DESIGN BRIEF ADDENDUM

770 SOMERSET STREET WEST

RE: 770 Somerset Street West & 13 Lebreton Street North, Ottawa
Design Brief Addendum
Zoning By-law Amendment, D02-02-17-0096
Site Plan Control Revision, D07-12-17-0136

770  
SOMERSET ST  
DETAILS

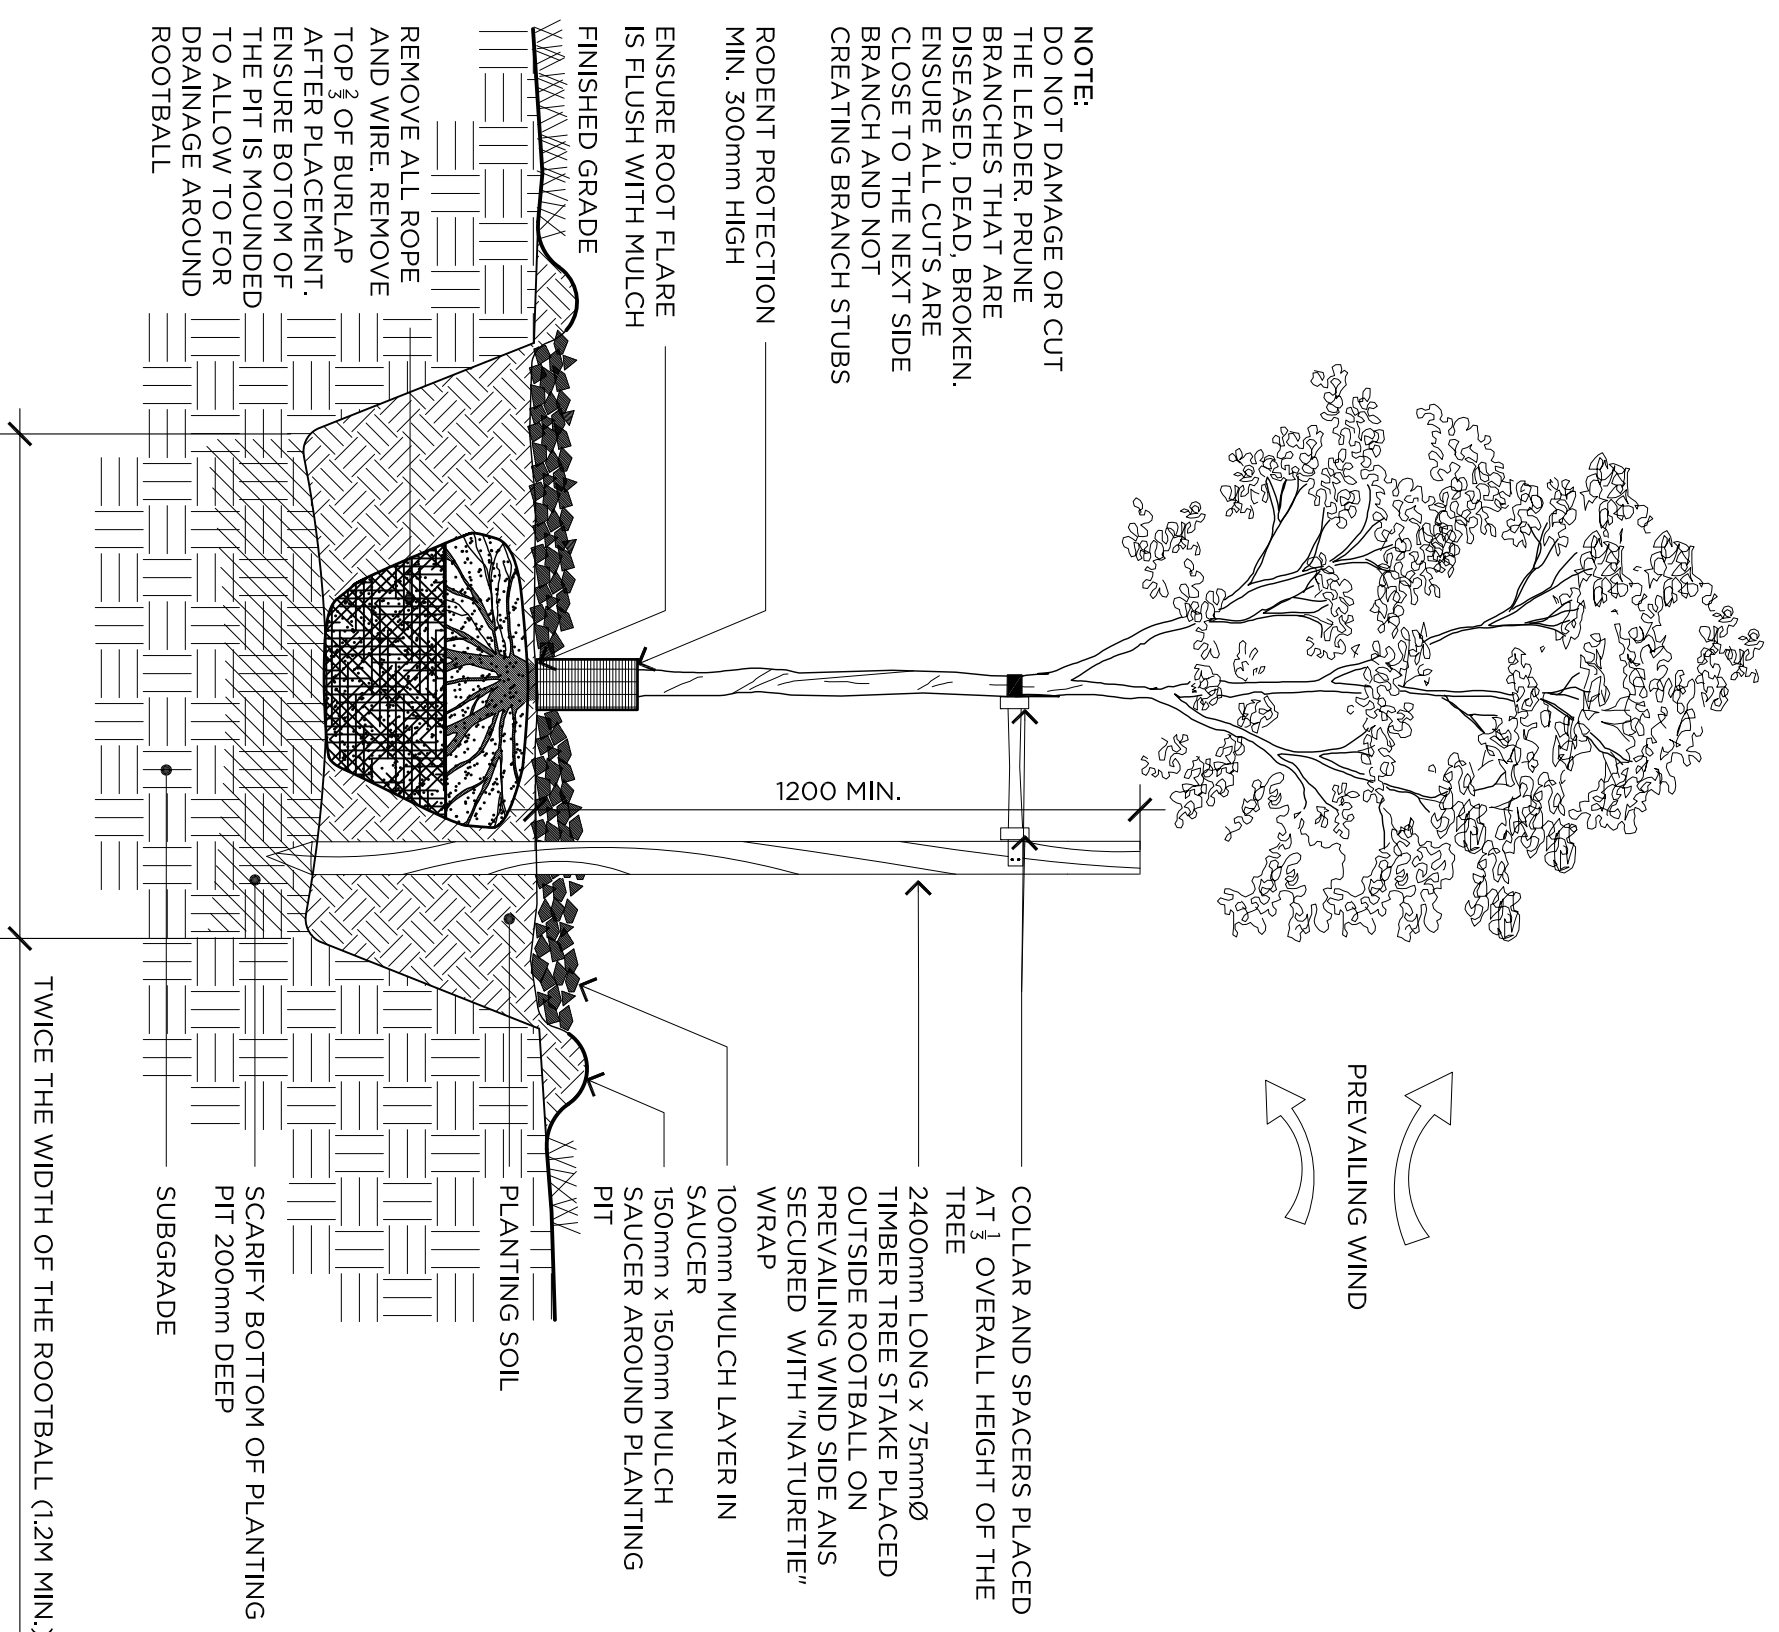
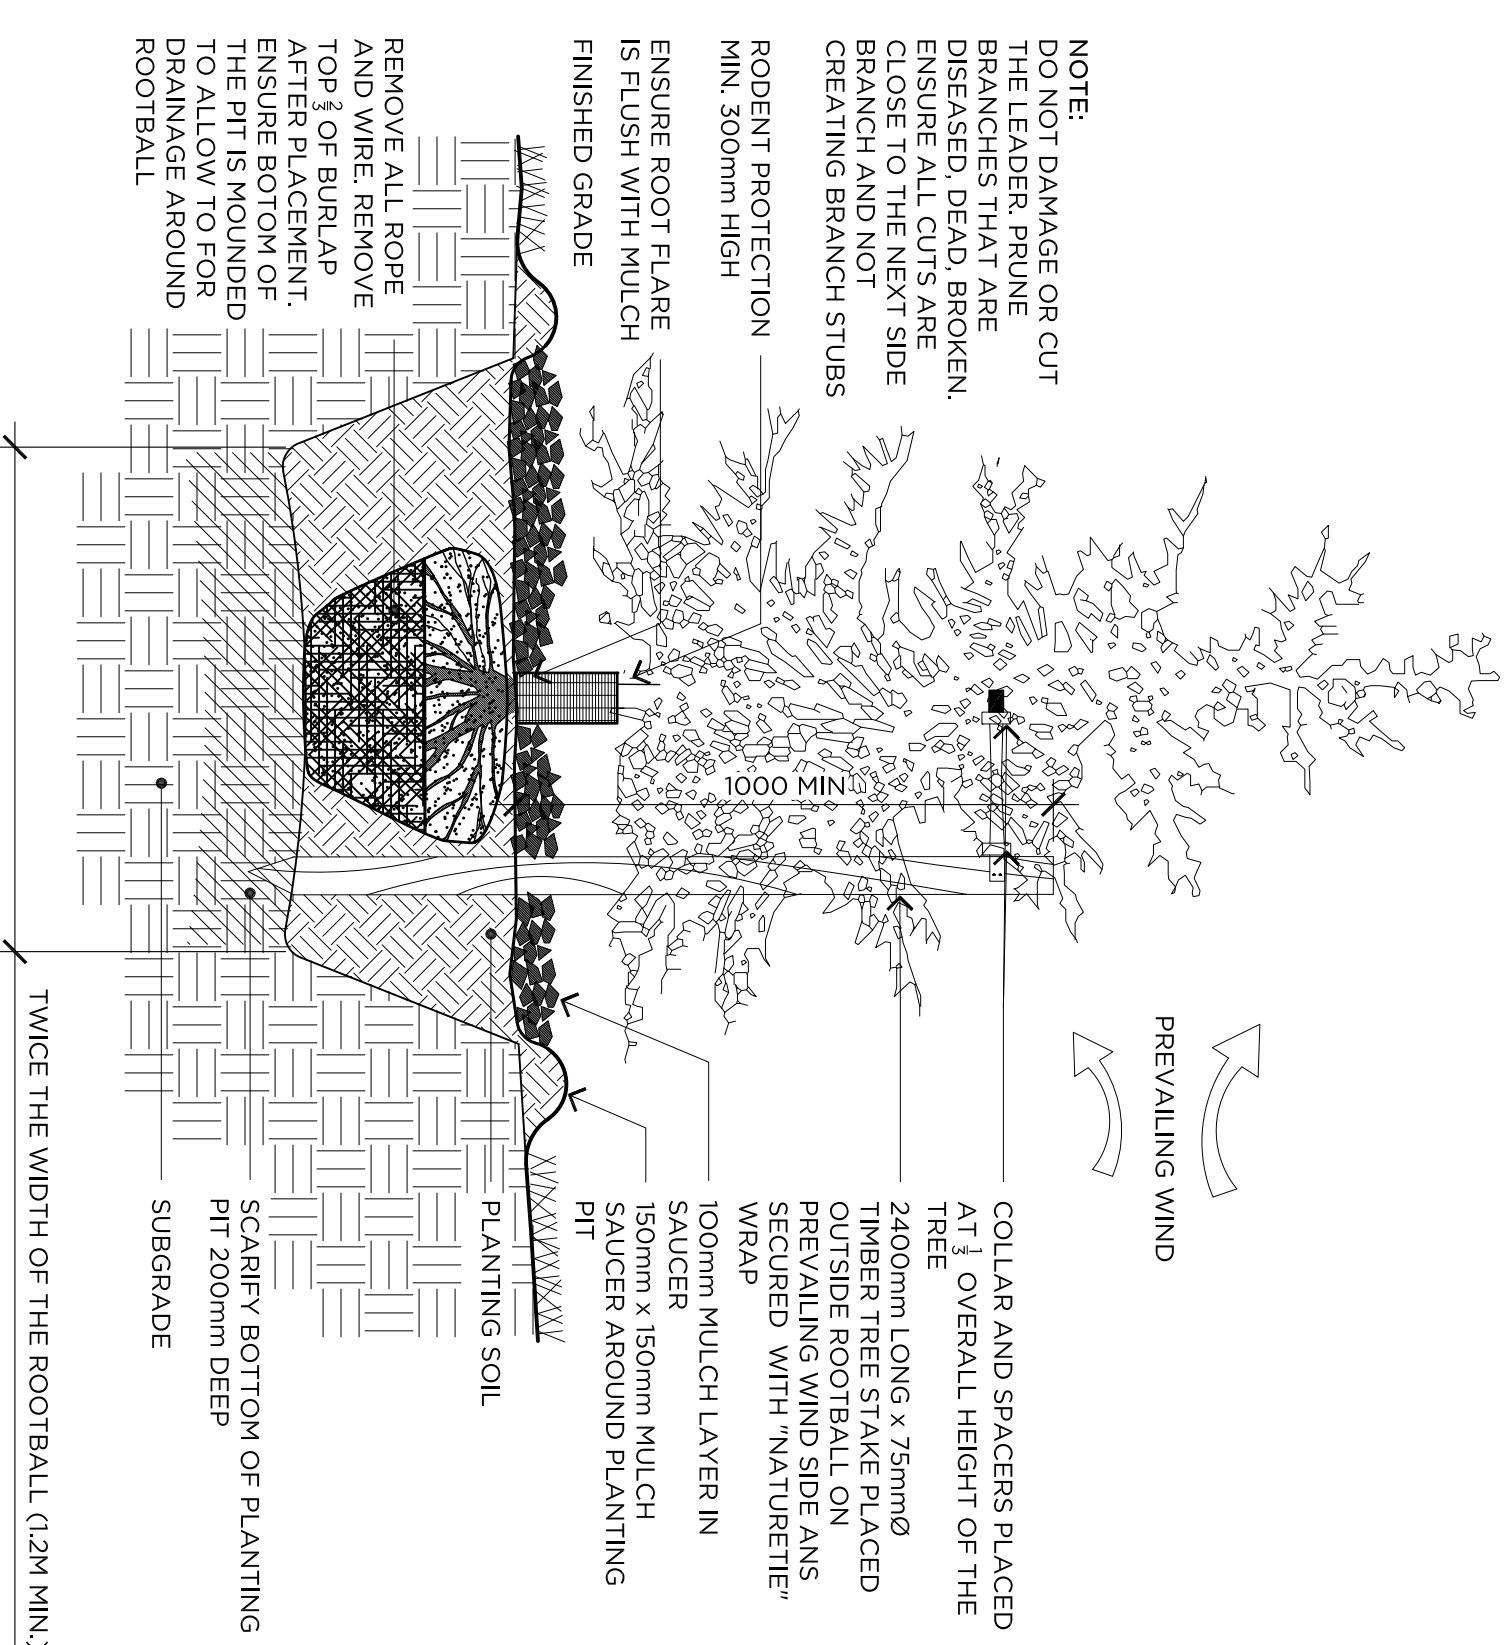
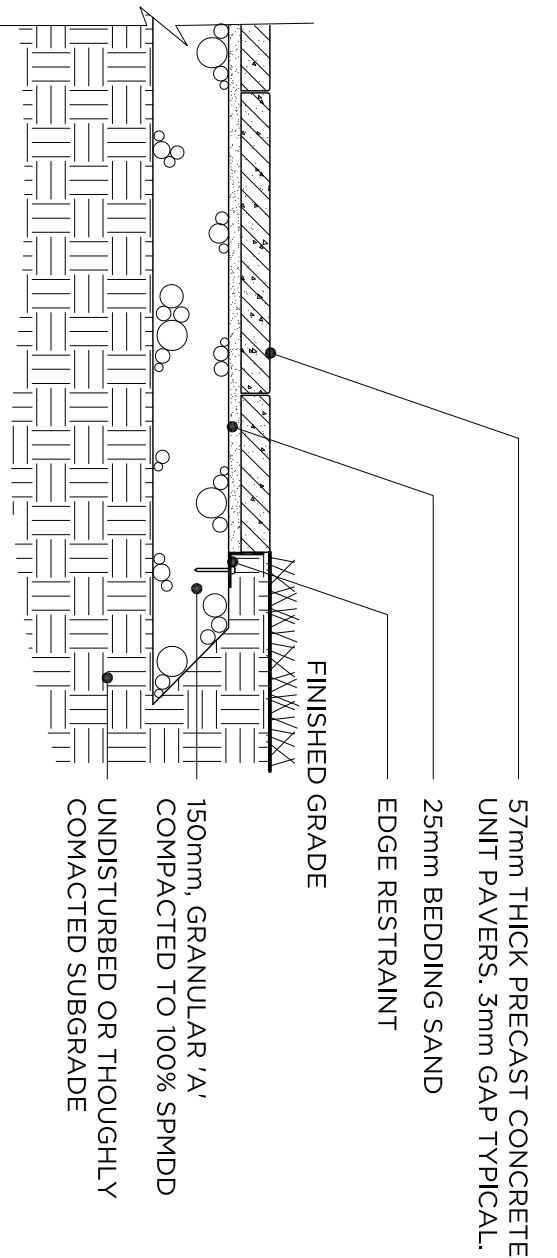
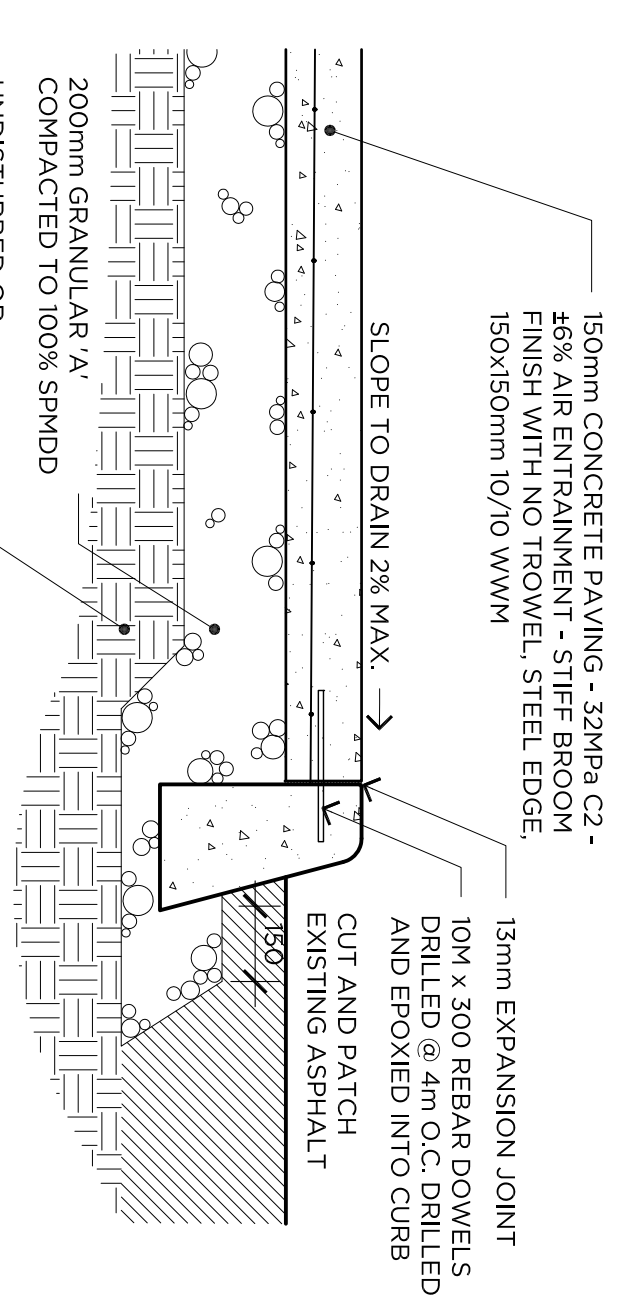
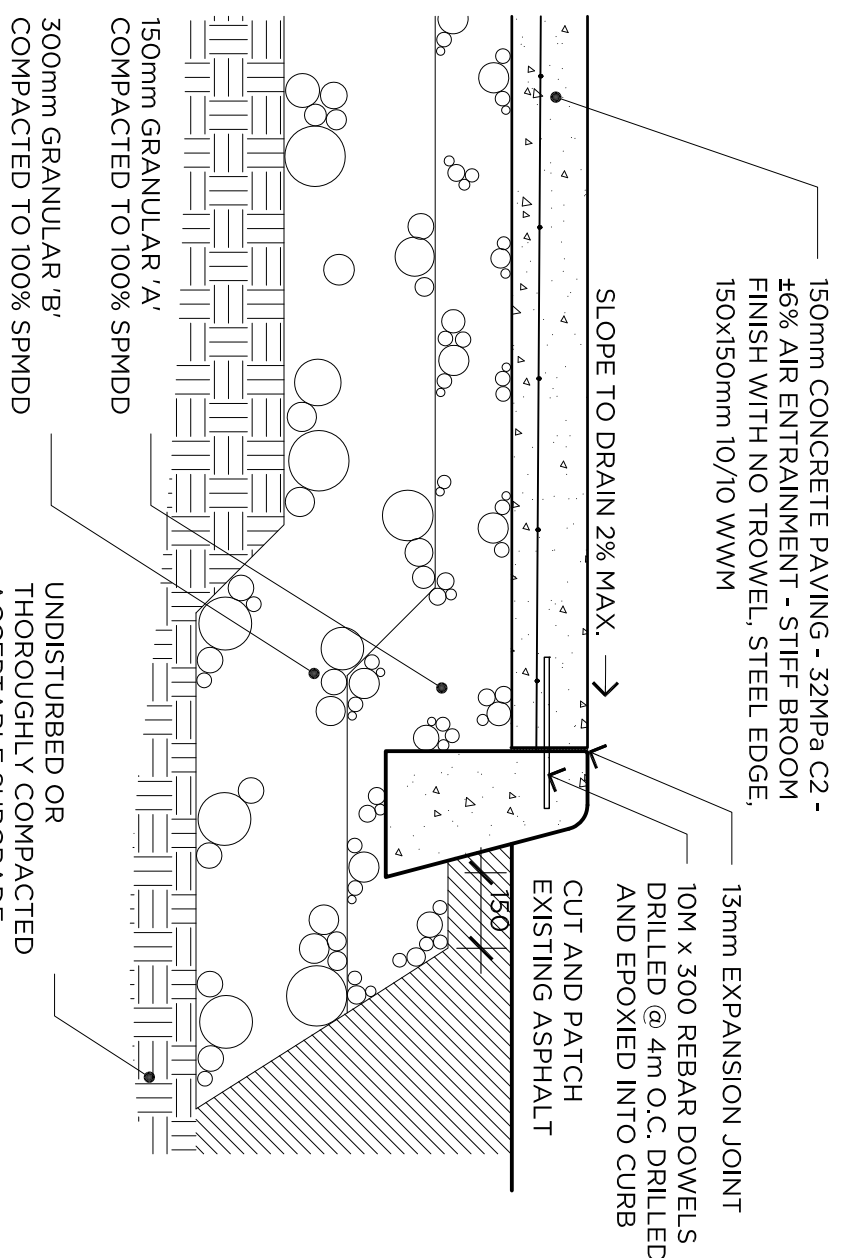
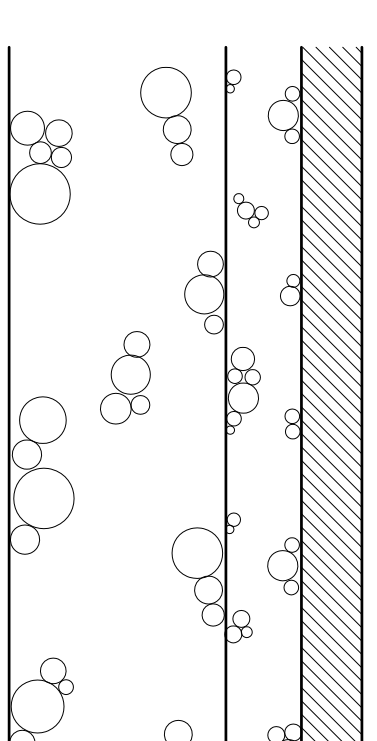
- / *At the street level, the Panel recommends utilizing bollards and appropriate paving treatments. Ensure that existing transformers are identified in order to ensure the creation of a cohesive pedestrian environment.*

- / *Enlarge proposed planters in order to sustain the plants shown in the renderings. The Panel further advises adding trees to the Lebreton Street streetscape.*

Broom finish concrete is proposed at the street level. It is unclear how bollards would enhance the street level.

The planters along the Somerset Street frontage have been modified to sustain the size of the plants proposed. Four (4) small trees have been located along Lebreton Street North.
